RFI

RFI #: 200
 Date: 10/22/2012
 Job: EB-02 Keller Springs Lofts
 Phone: 877-777-5115

Subject: B2 Part 4 unit Columns and patio dimensions

SHEET NUMBER
3.1C
BLDG PLAN 'C'

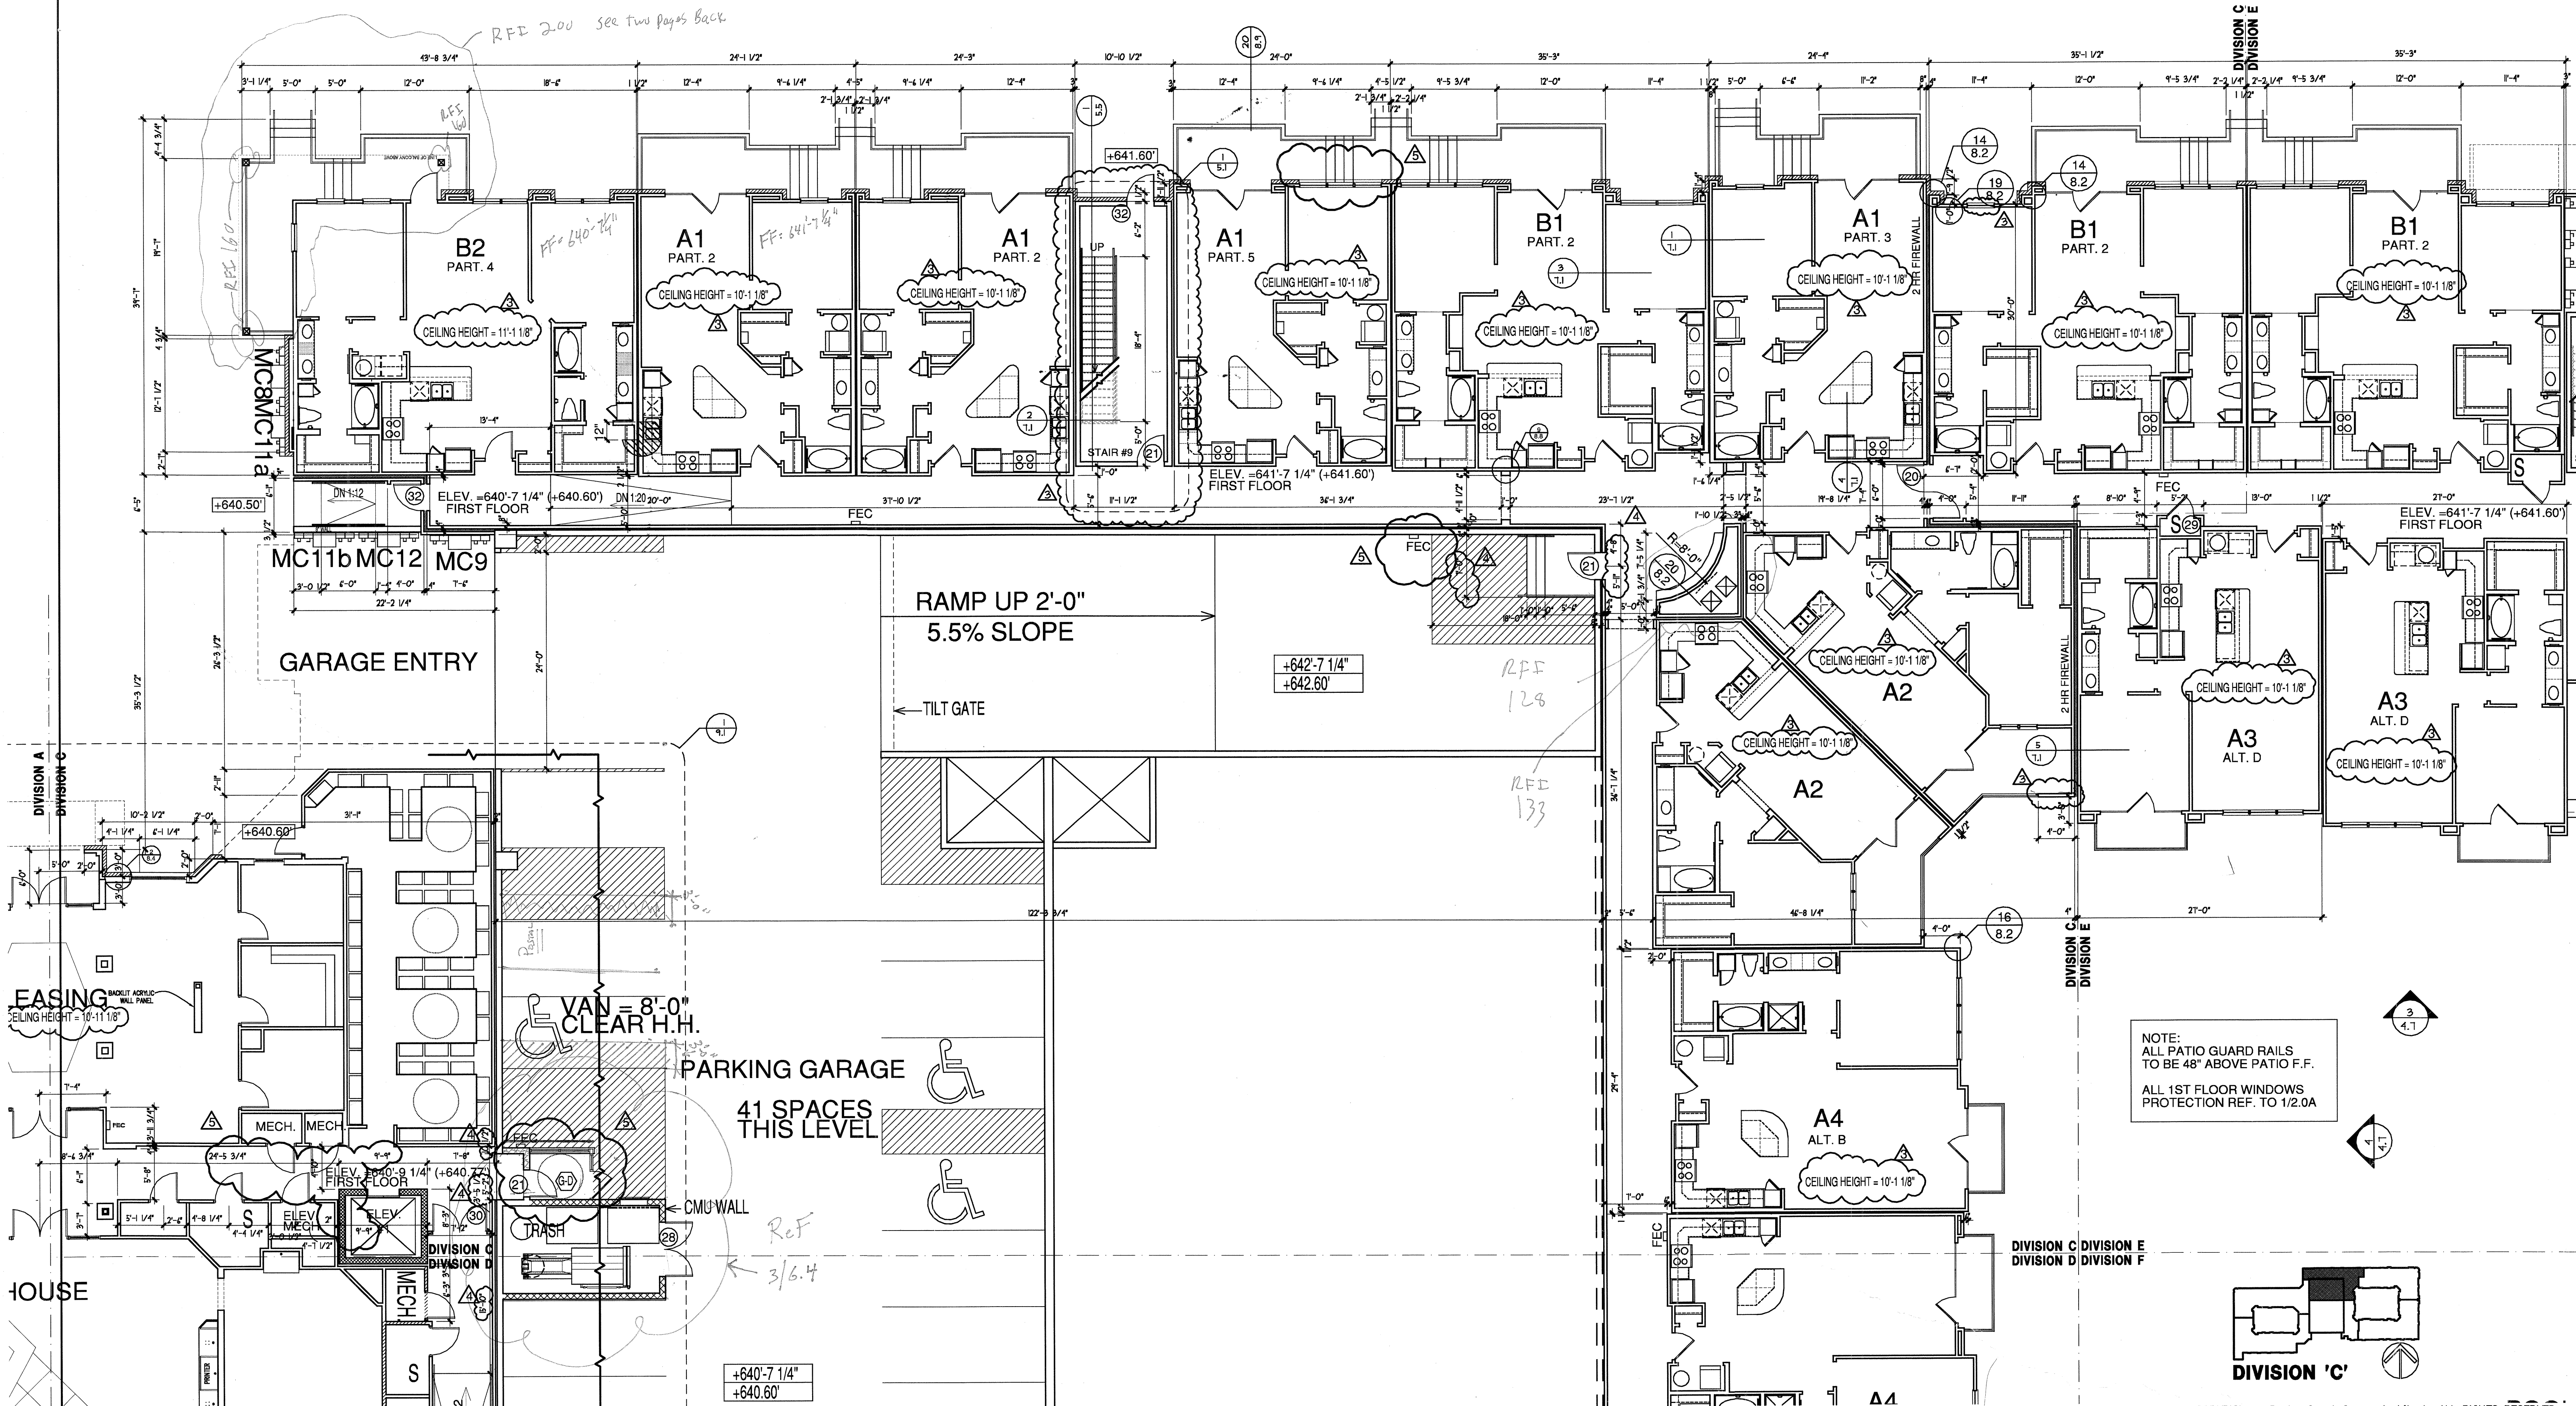
Request: The attached RFI from Red River Framing is in reference to the B2 Part 4 unit columns and patio dimensions on 2/2.7A vs. the B2 Part 1 unit balconies above shown on 1/2.7A. The B3 Partial 1 units show the supporting walls & post the support columns from the B2 Part 4 units. Please review and advise.

PPO takes no exception to the cantilevered truss solution proposed below.

BGO suggests cantilevering the trusses for these B2 units in question as shown in the next pages of this PDF only if the Trusses are signed and sealed by an engineer in the state of Texas.
